12 August 2010

**REQUEST FOR ADDITIONAL INFORMATION
THOMAS STREET CAR PARK MP09_0066**

We write to you on behalf of the applicant, Welles Thomas, in relation to your email dated 23 July 2010 requesting additional information in relation to the proposed redevelopment of the Thomas Street Carpark, Chatswood. Our response is provided below, for ease of reference I have included your original comments (*italics*) with our response under each comment.

A-0113 /B  
PRELIMINARY

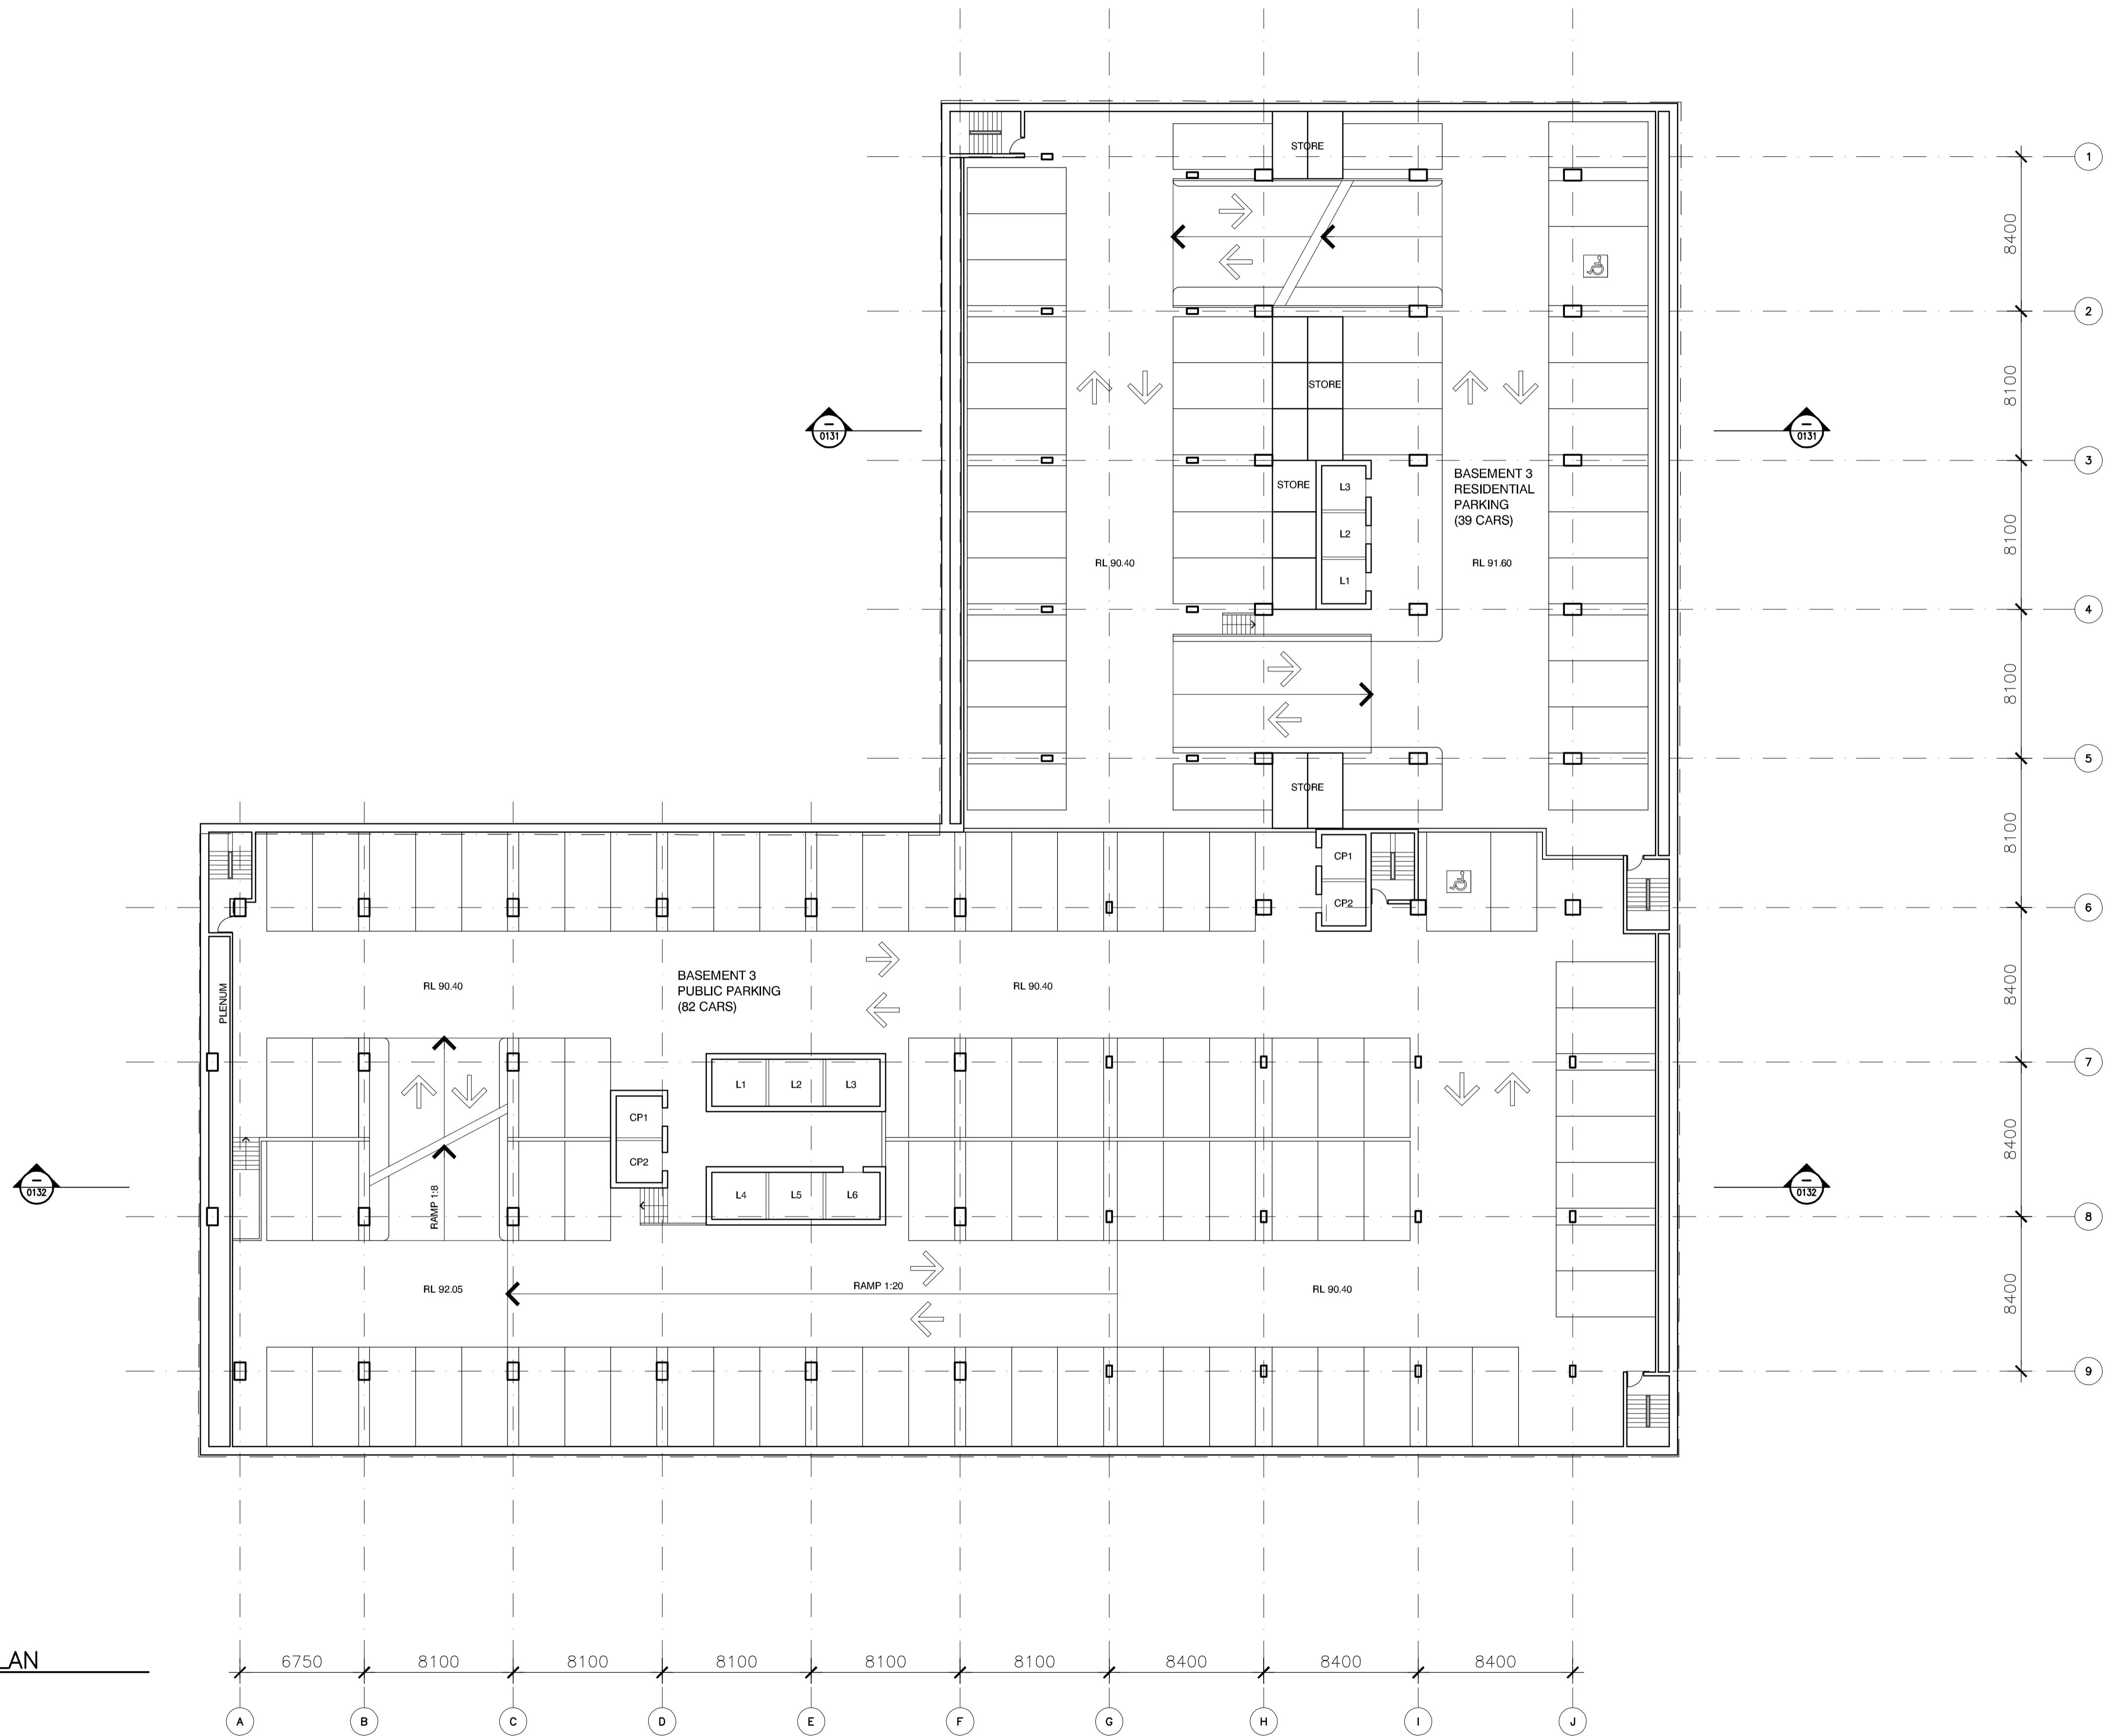
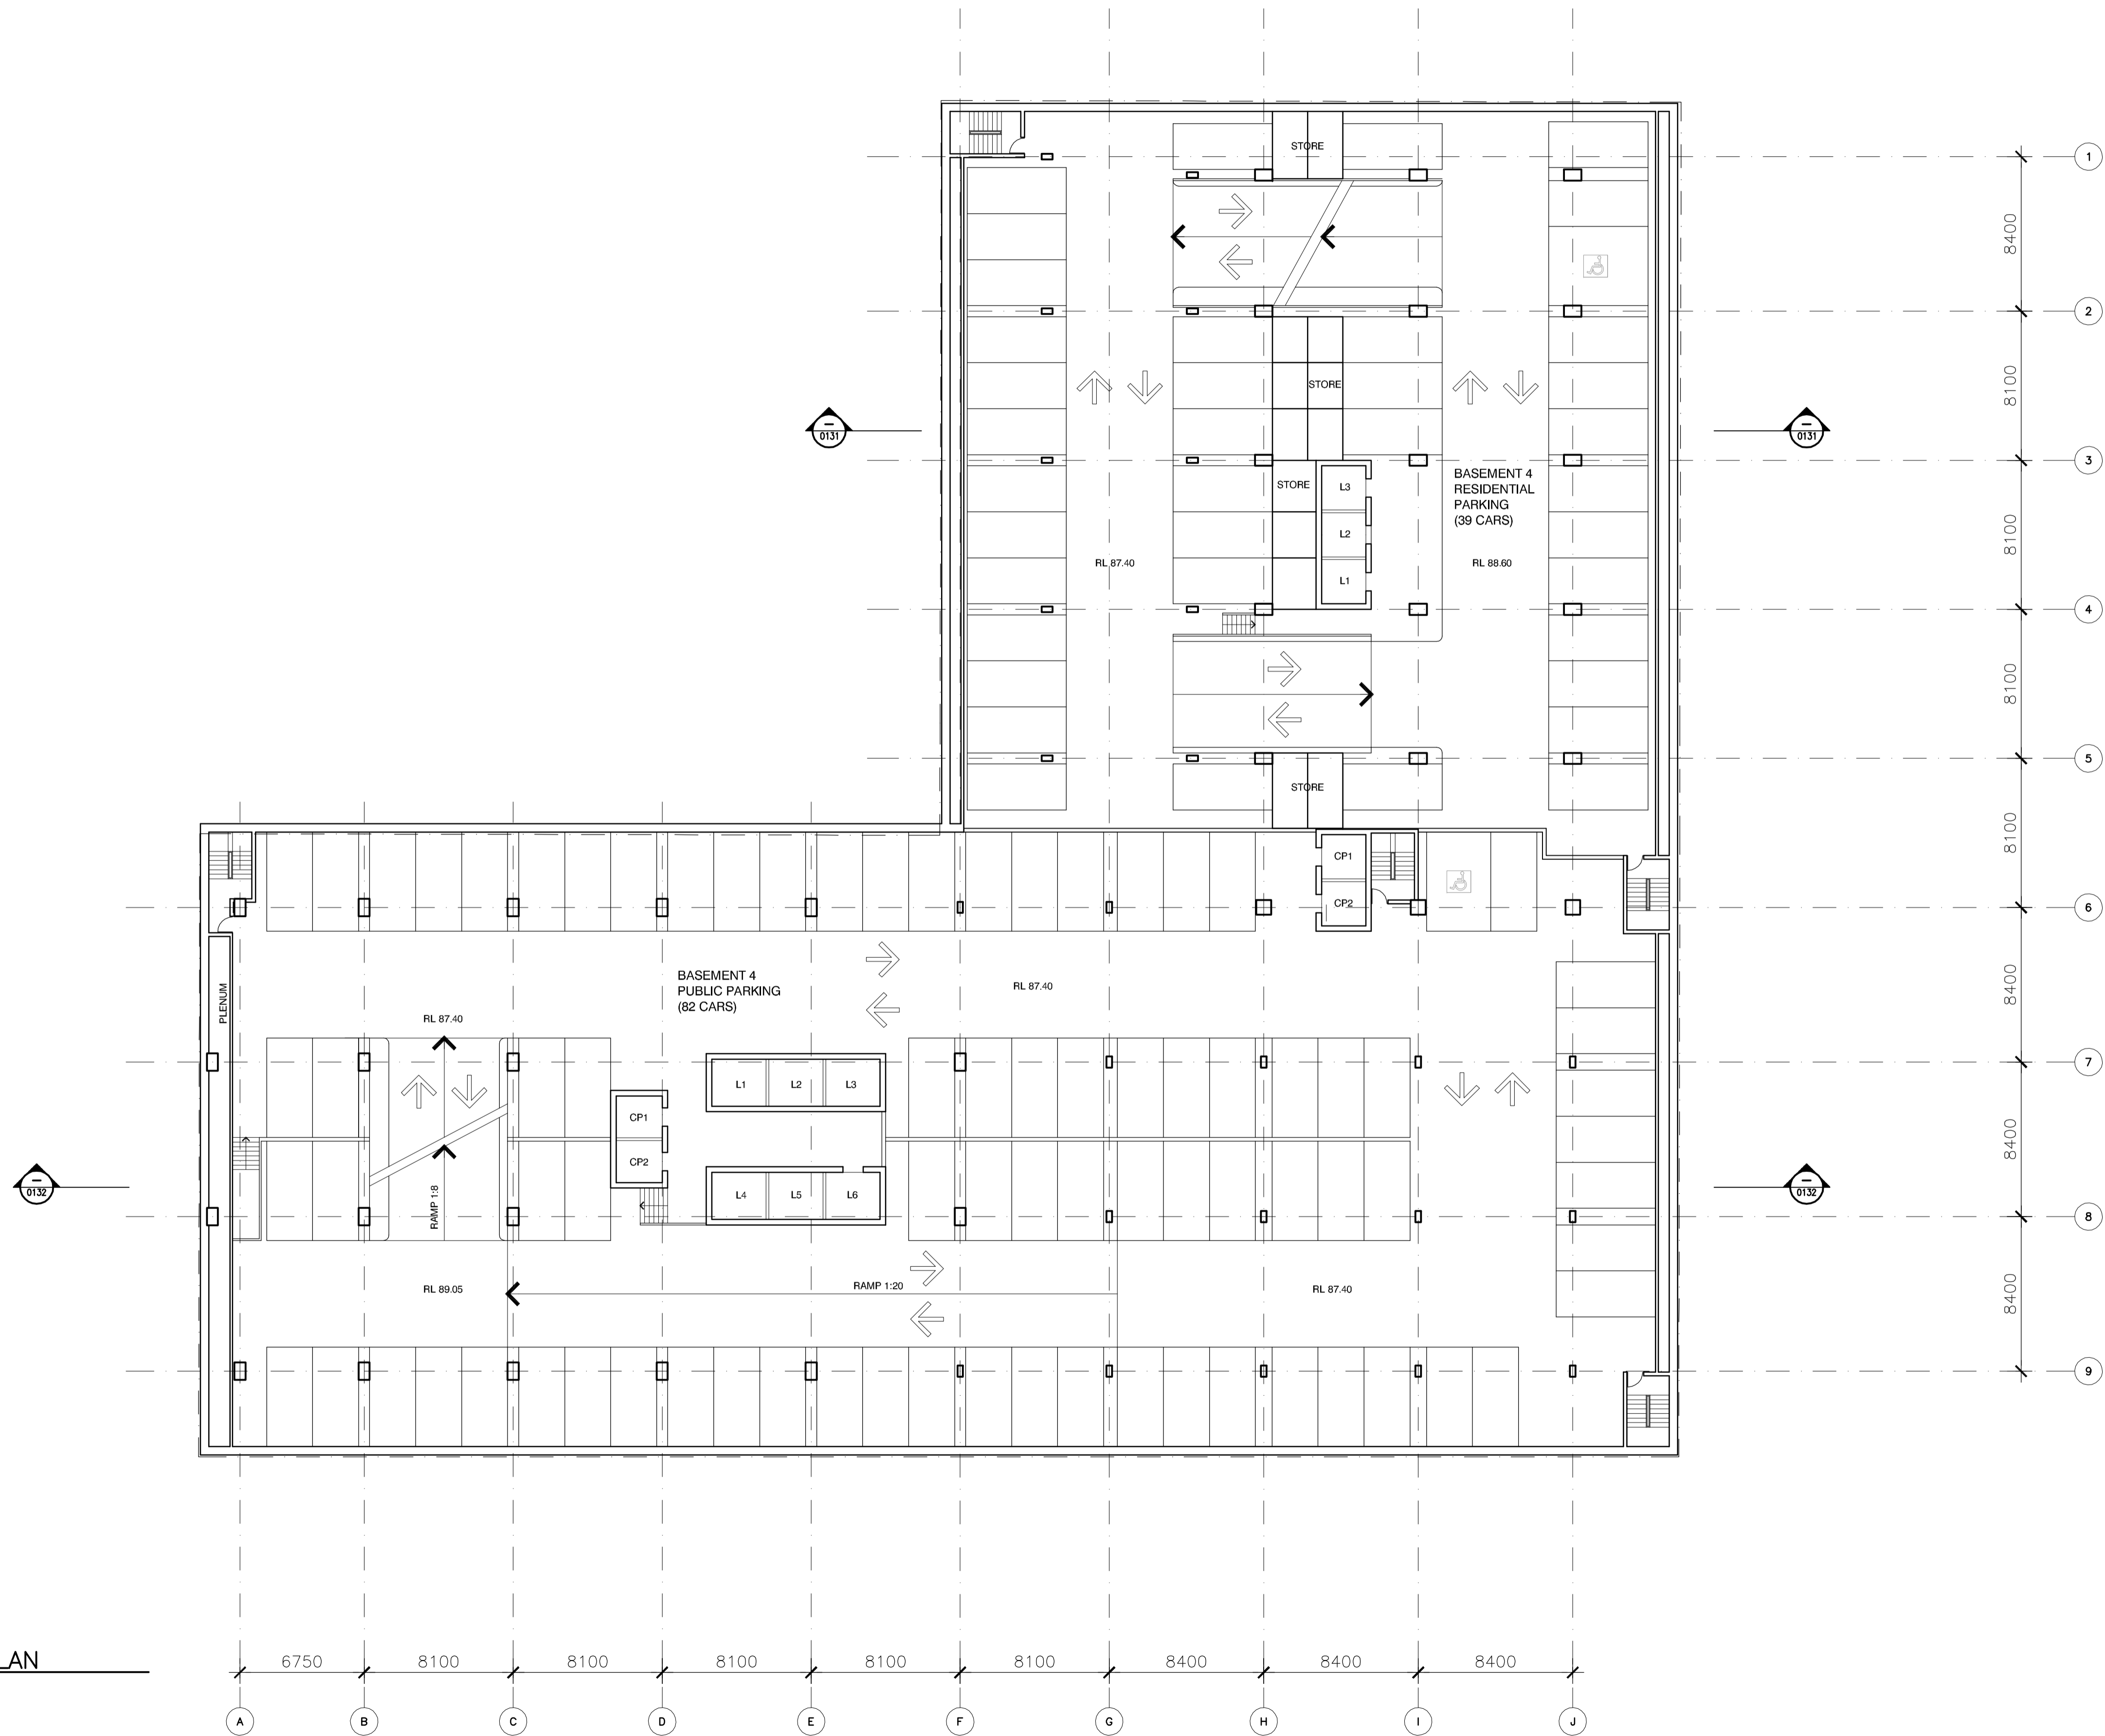
"The Department requests proper architectural plans drawn at an appropriate scale be submitted for any proposed modifications to the building layout."

Modifications to the building layout will occur below ground and will not have any impact on the operation or amenity of neighbouring property. It is requested that the Department of Planning impose a condition of consent requiring the submission of detailed architectural plans to the Department of Planning prior to the issue of a Construction Certificate.
